| CLIENT: | Whataburger | | DATE: | 2/16/2022 | | Case No: |
| PROJECT: | Whataburger NM - San Pedro and Alameda | | REFERENCE: | 2nd DRB Application Comments (via Email) | | PR2018-001346 |
| The following comments are from: Jay Rodenbeck/Jolene Wolfley/Robert Webb | | | RE: DRB - Major Case Comments | | | |

SHEET NO:  
**A2.3**

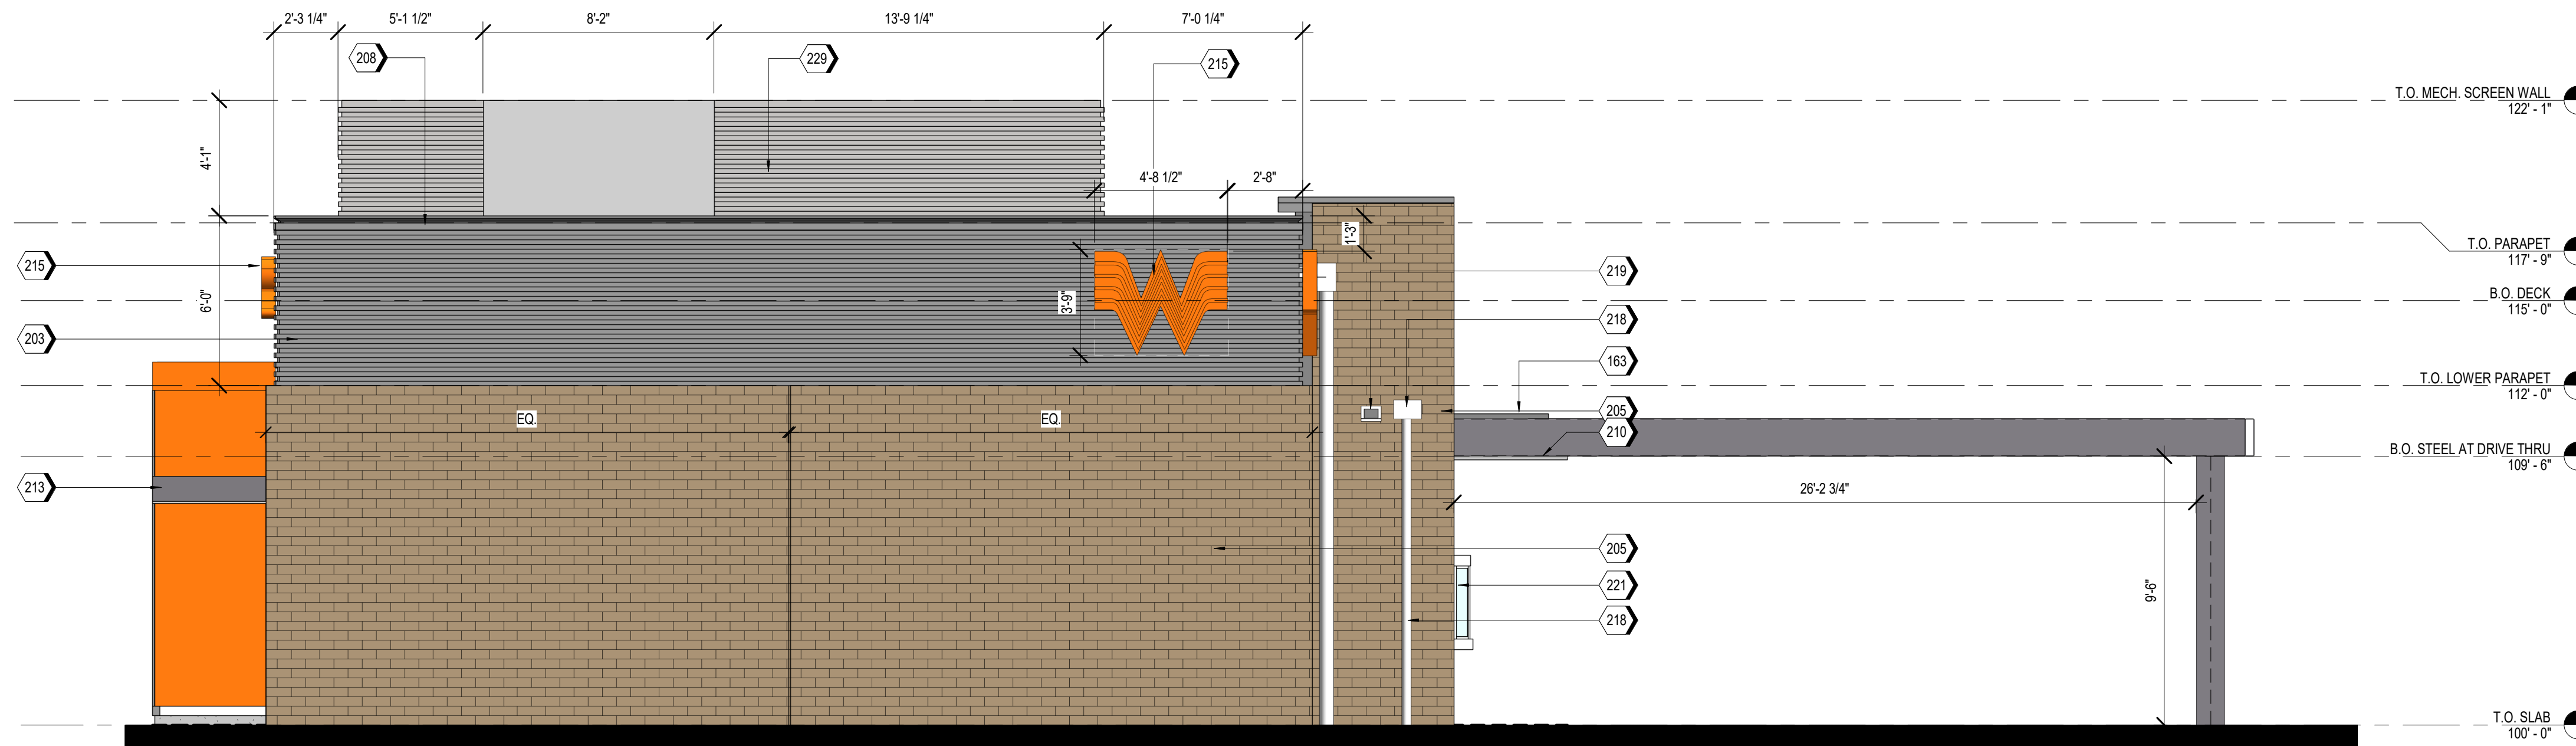
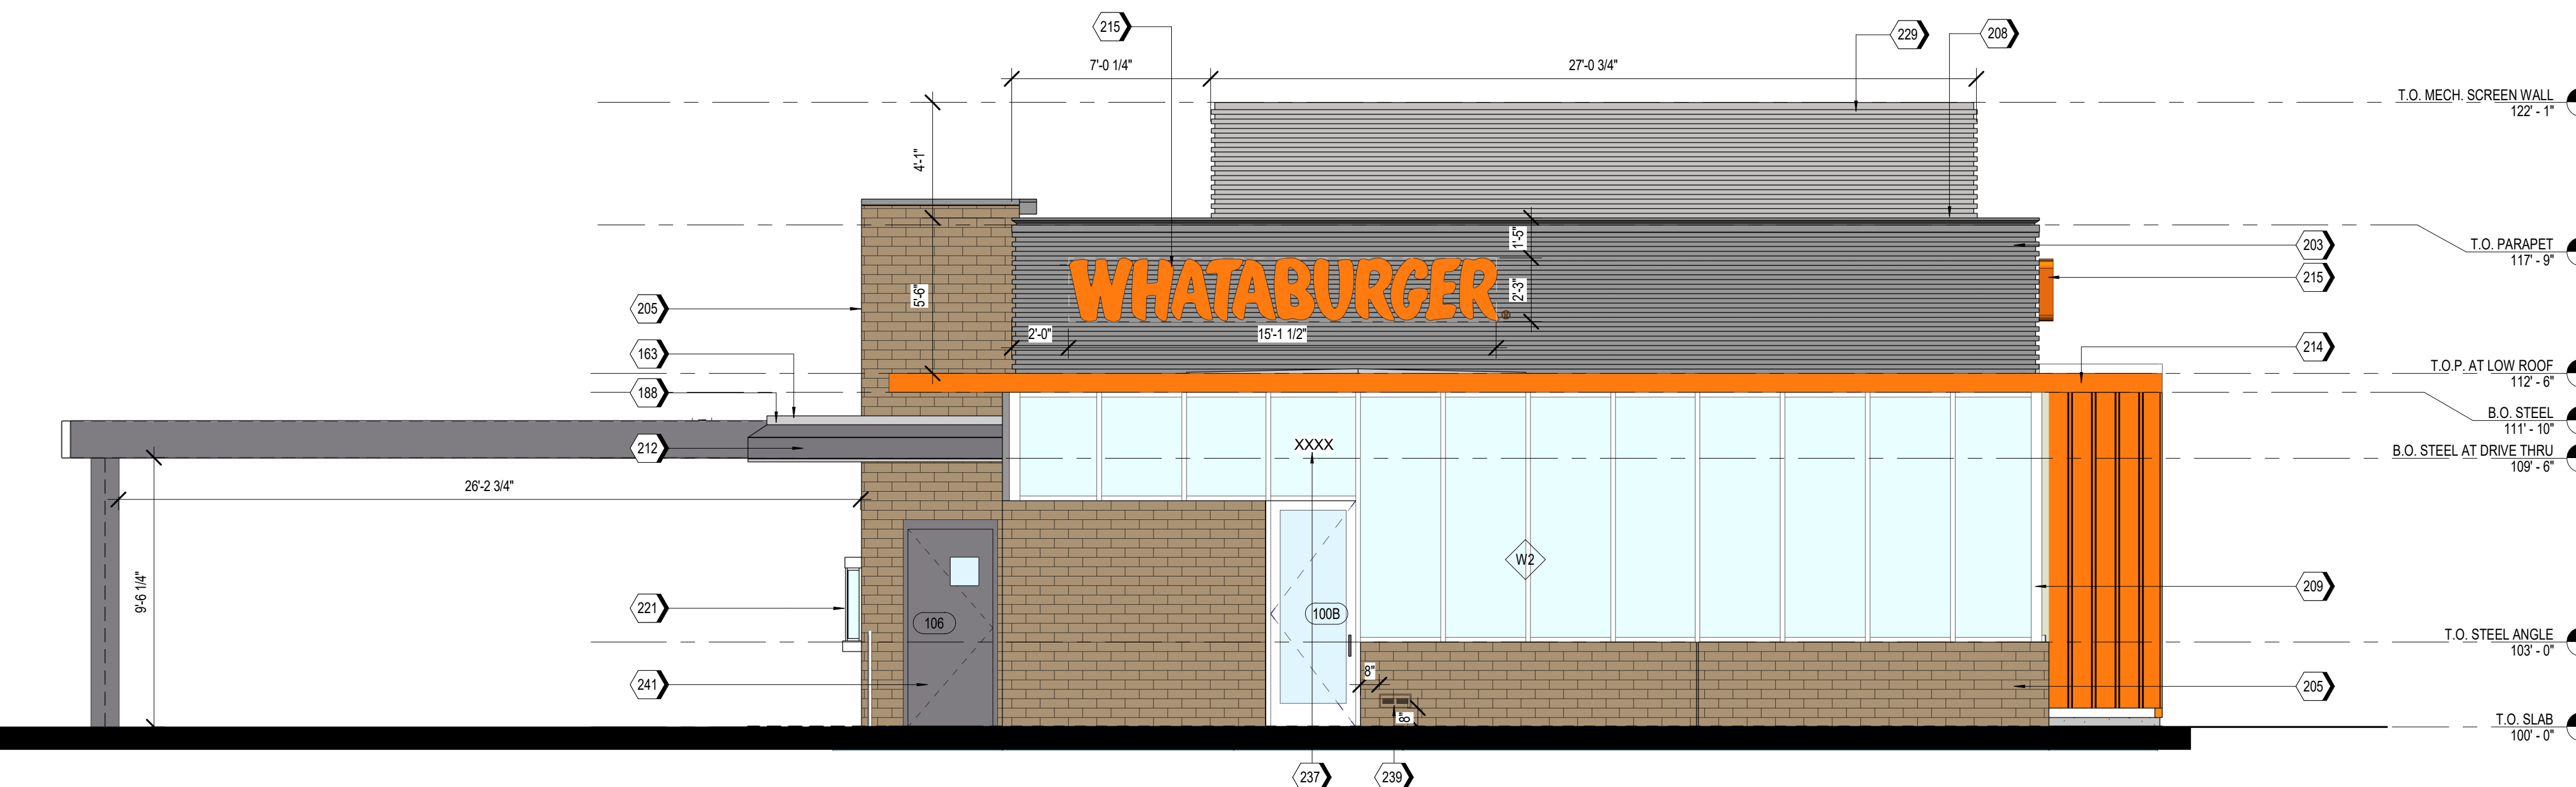
| 3 | 1 | IDO section 5-11 (E) street-facing Façade requirements for North and West sides. Appears deficient on North street-facing façade. Please justify how these requirements are being met. | SEG | Added full awning over the pick-up window creating an arcade over the DT lane further creating sun shade for DT vehicles. Other supplemental canopy includes an orange canopy that wraps around the north west building corner and provides an exterior feature to break apart the horizontal facade. At the Pick-up window the brick was fully raised creating a break in the roofline canopy and indulation along the horizontal facades. See updated elevations | KZ |
| 8 | 1 | Wall signs: Should show Wall Sign percentage of façade for square footage covered on each wall with proposed signage, as per IDO Table 5-12-2, Section 5-12(F)(2). | SEG | Dimensions and percentage for wall signs added to elevations | KZ |
